Able Marine Energy Park

Material Change 2

Applicant's Responses to

Written Questions

Scale:	Drawn By:	Checked By:	Approved By:
NTS@A1	D Almeida	R Crum	R Crum
Date:	07/12/2020	12/02/2021	12/02/2021
Drawing No:	AME-036-10009	Revision:	C

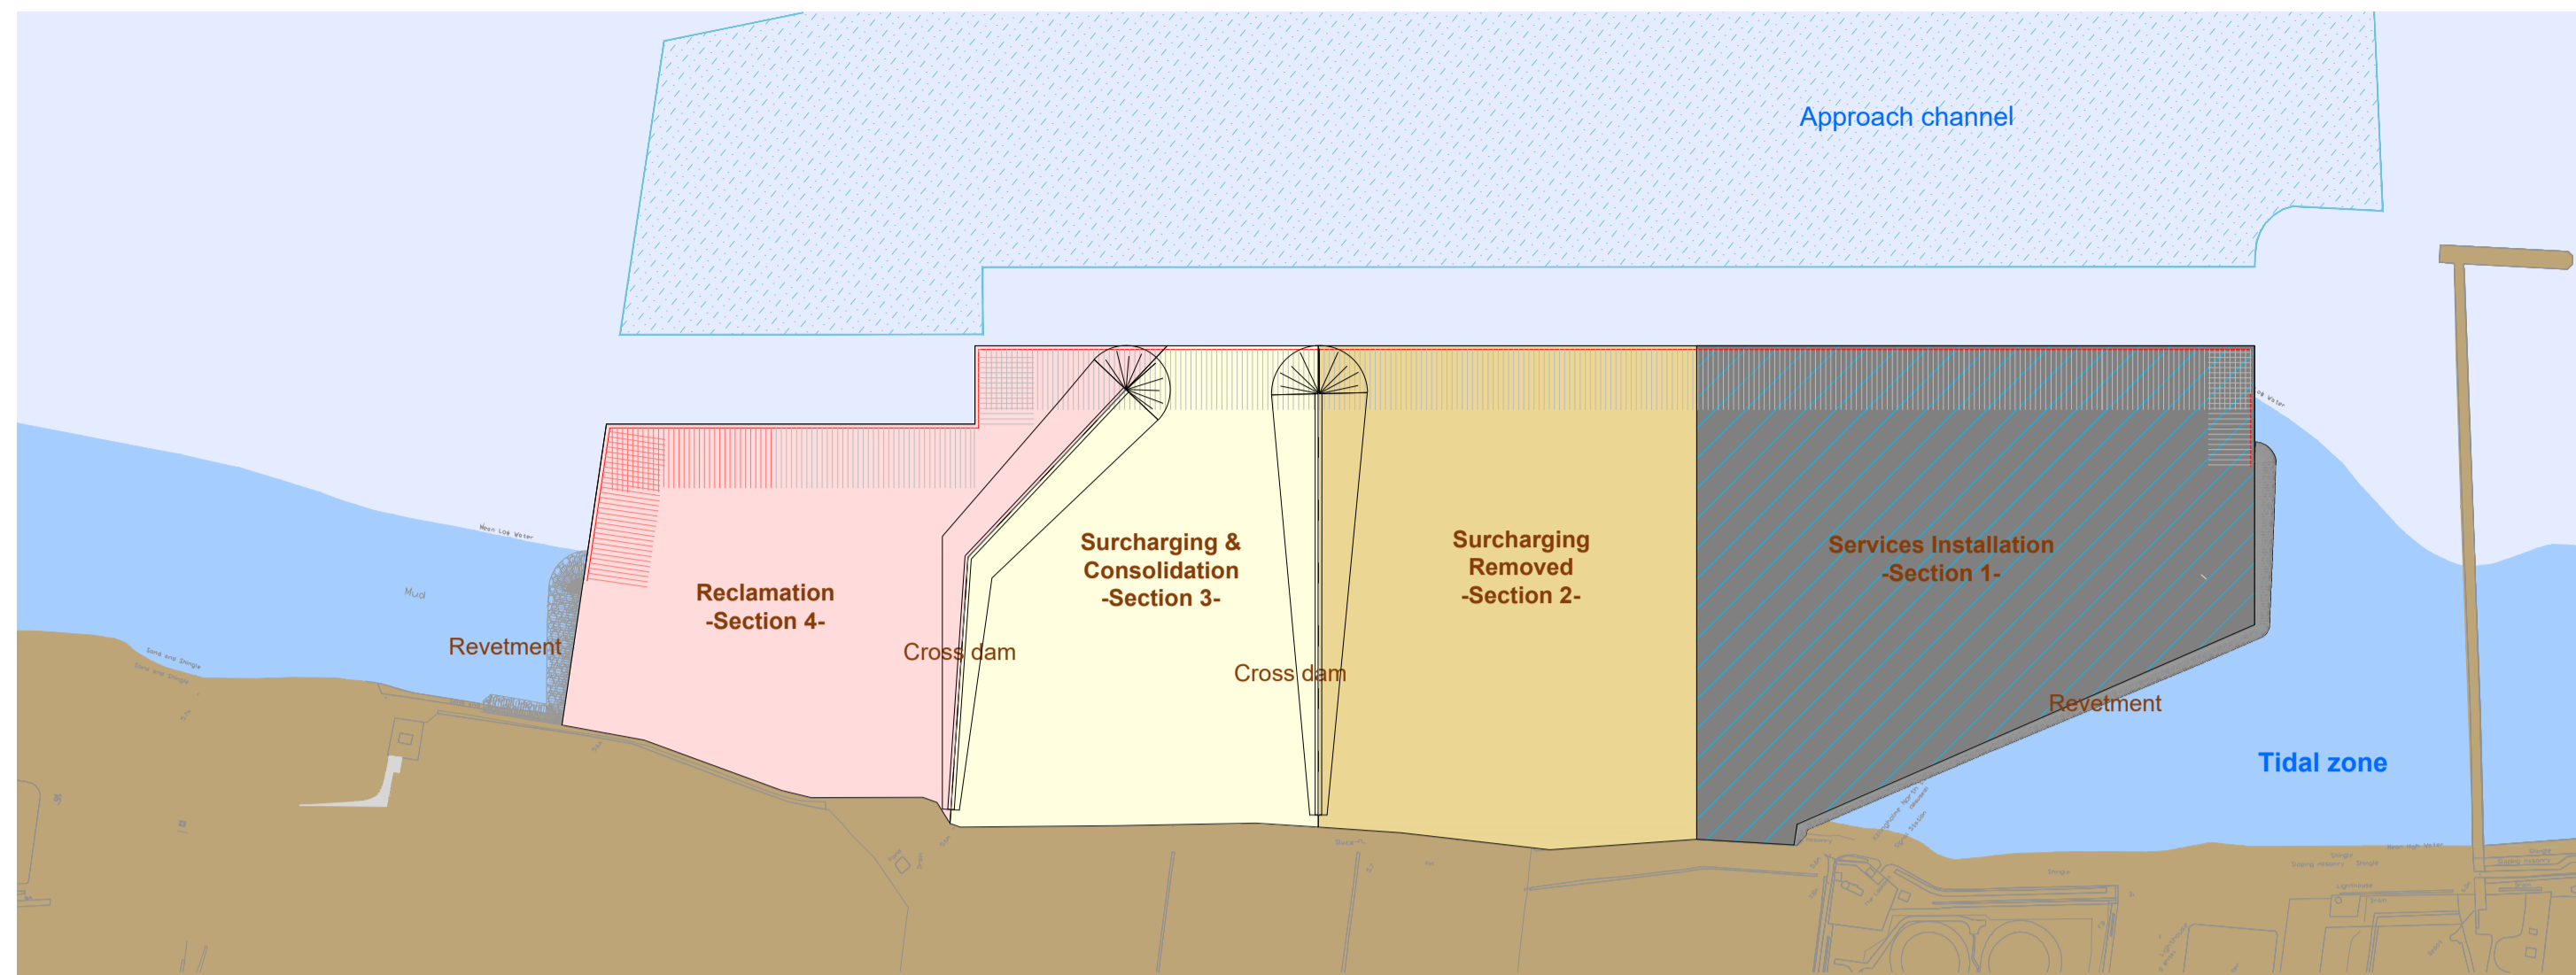
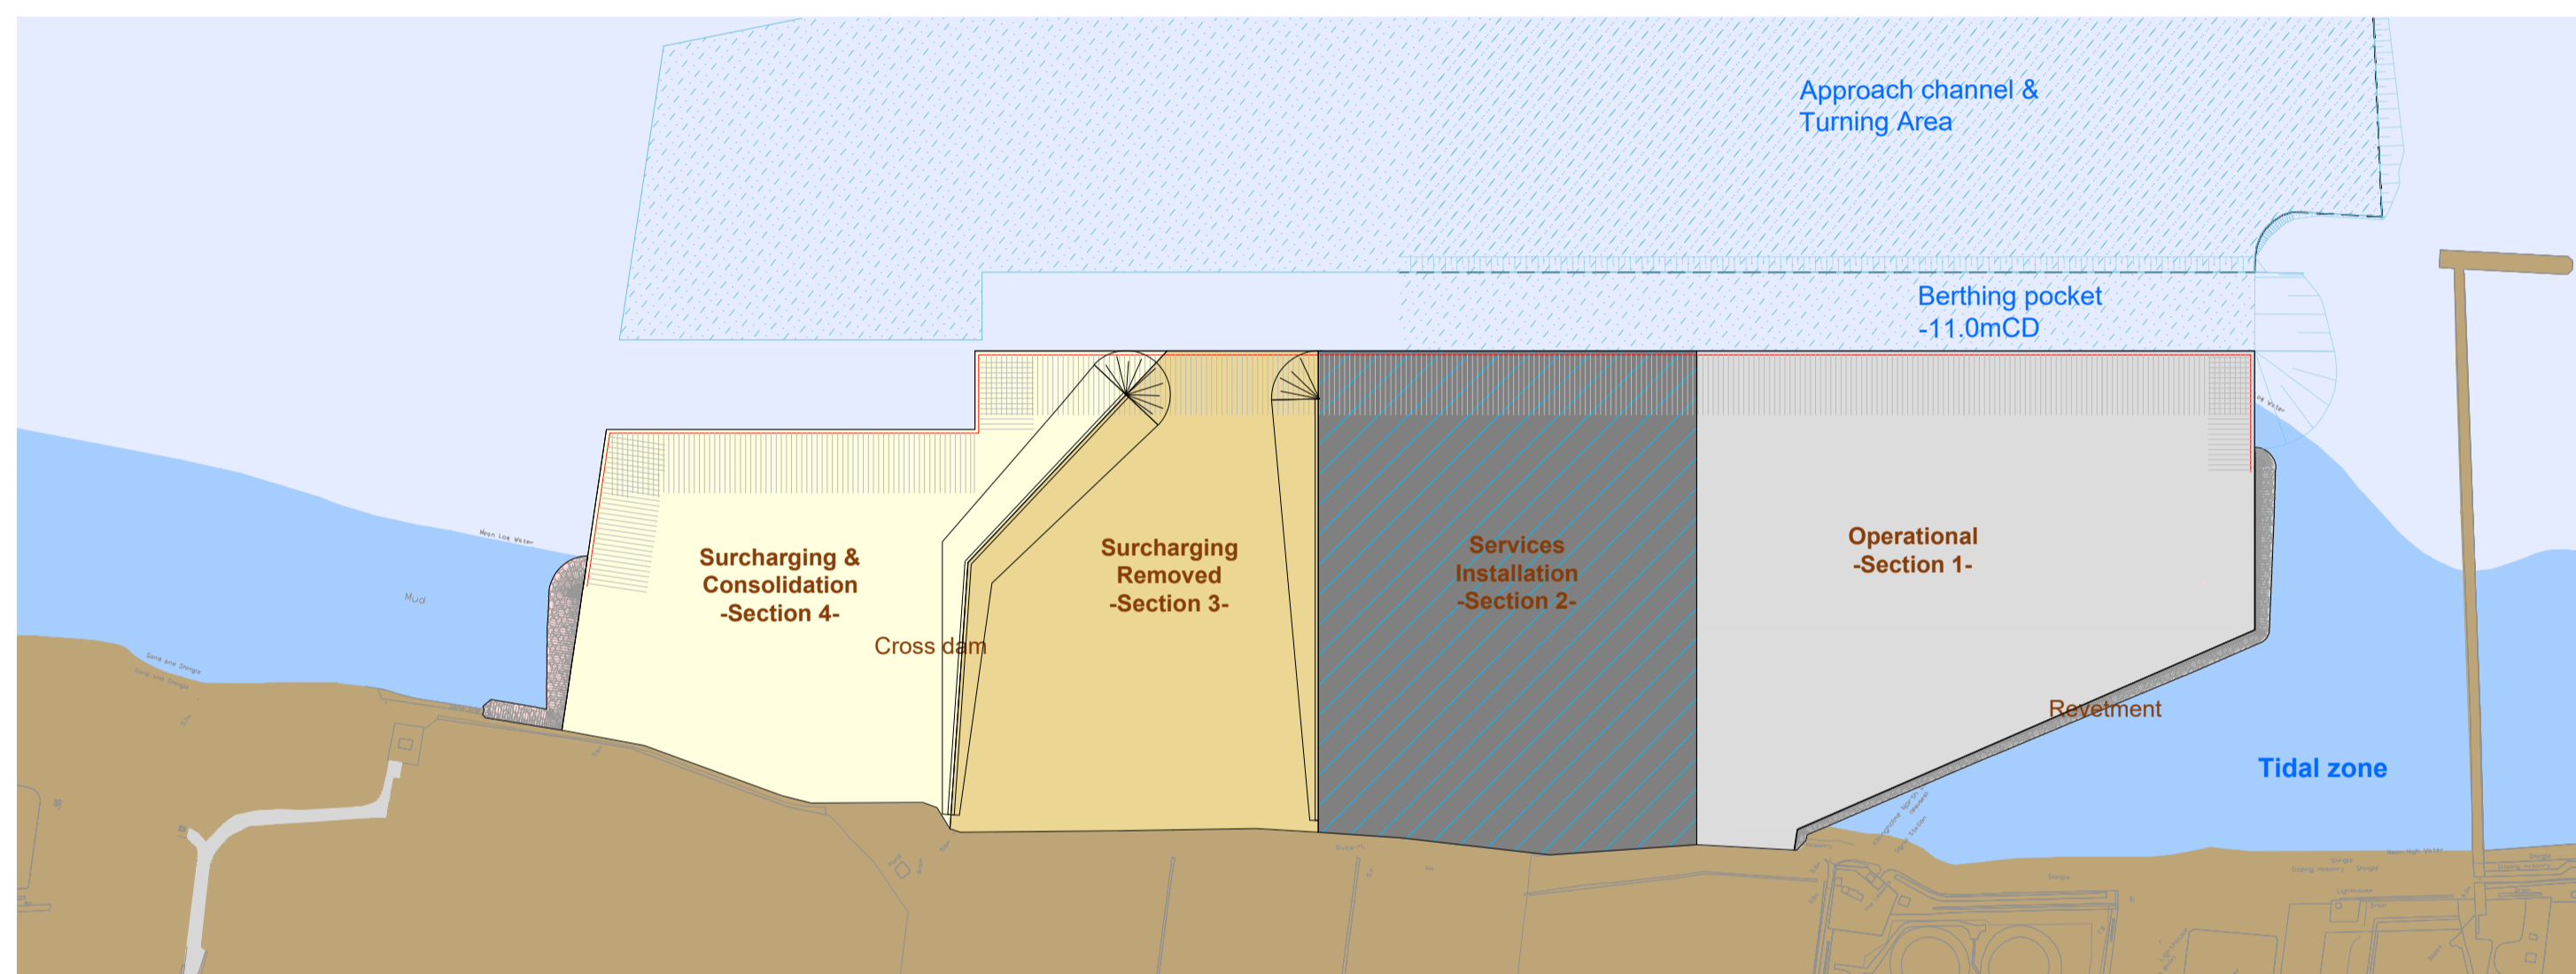
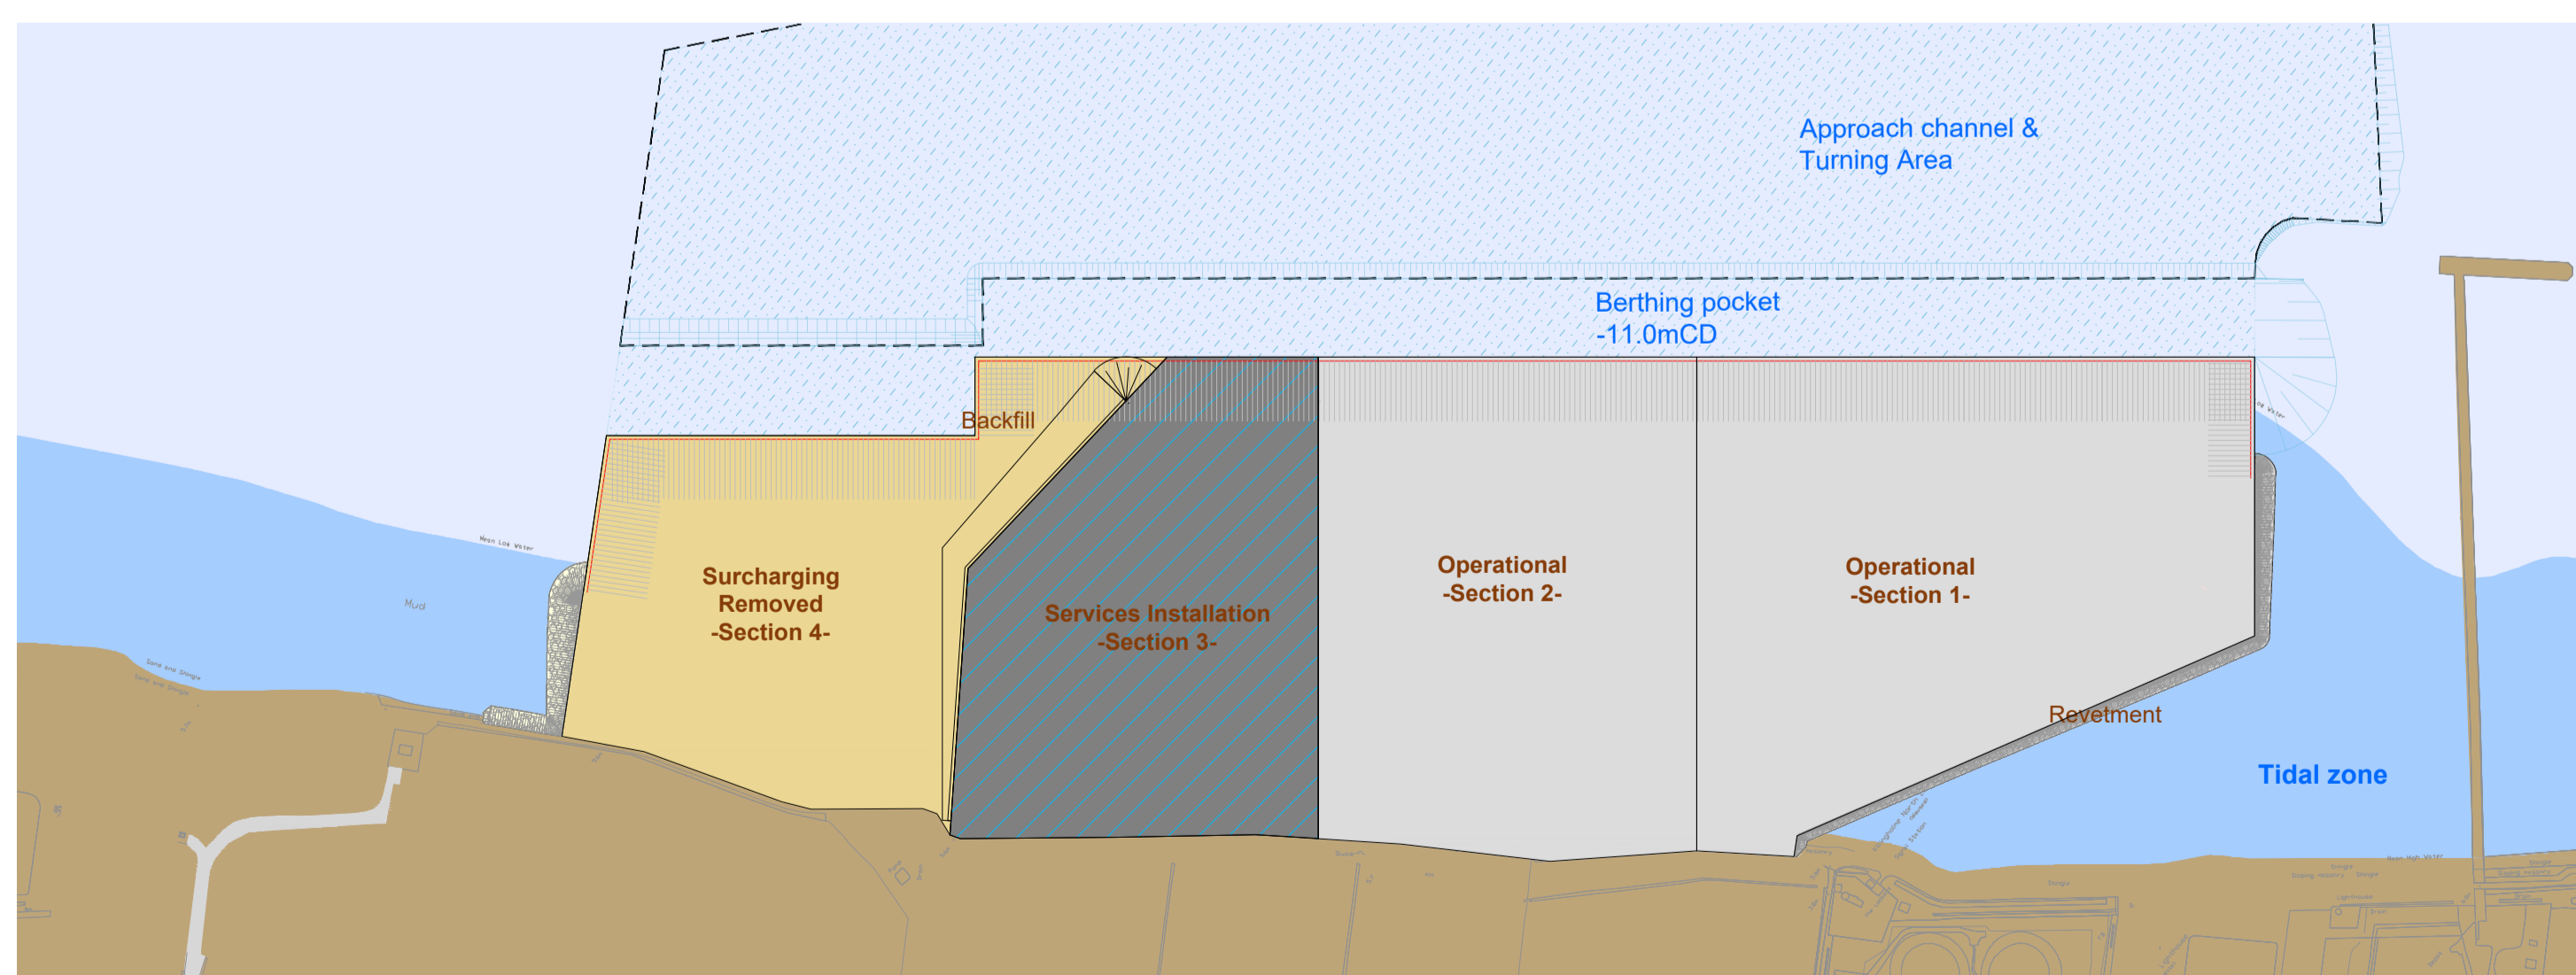
ExQ2	Question to:	Question:	
1. General and Cross-topic Questions			
Q1.01	App	<p>Pease supply A3 size copies of drawings AME-036-10009 rev C and AME-036-10010 rev C.</p> <p>These were previously supplied as A1 size copies when A3 size was requested. (The ExB already has AME-036-10011 rev C as it applies to both construction process alternatives).</p>	<p>The Applicant supplied Revision D of these drawings (AME-036-10009 and AME-036-10010) in response to ExQ1 1.0.1. The draft amendment order (REP1-014) now refers to both the Revision D and the Revision C versions as alternative options.</p> <p>A3 paper versions of Revision C, modified to A3 scale (and amended to Revision C1) have been issued under separate cover and are issued electronically with this response with document references TR030006/D4/2 and TR030006/D4/2A.</p>
Q1.02	App	<p>Re: ExQ1: 1.0.2, For clarity please confirm whether I am right to interpret drawing AME-036-10004 rev C as showing two prime alternatives -</p> <p><i>A: Anchor piles plus horizontal steel ties to quay piles</i></p> <p><i>B: Flap anchors plus diagonal steel ties to quay piles</i></p> <p>That each of these prime alternatives could be built without a relieving slab or could have one of two types of relieving slab –</p> <p>1: With vertical supporting piles without a crane rail beam</p> <p>2: With vertical piles and some diagonal piles supporting a crane rail beam</p> <p>There would, therefore (noting the Applicant's response to ExQ1:1.0.3), be six overall alternatives – A, A1, A2, B, B1, B2.</p>	<p>The Applicant confirms that the Planning Inspectorate has interpreted the drawing AME-036-10004 rev C correctly.</p>
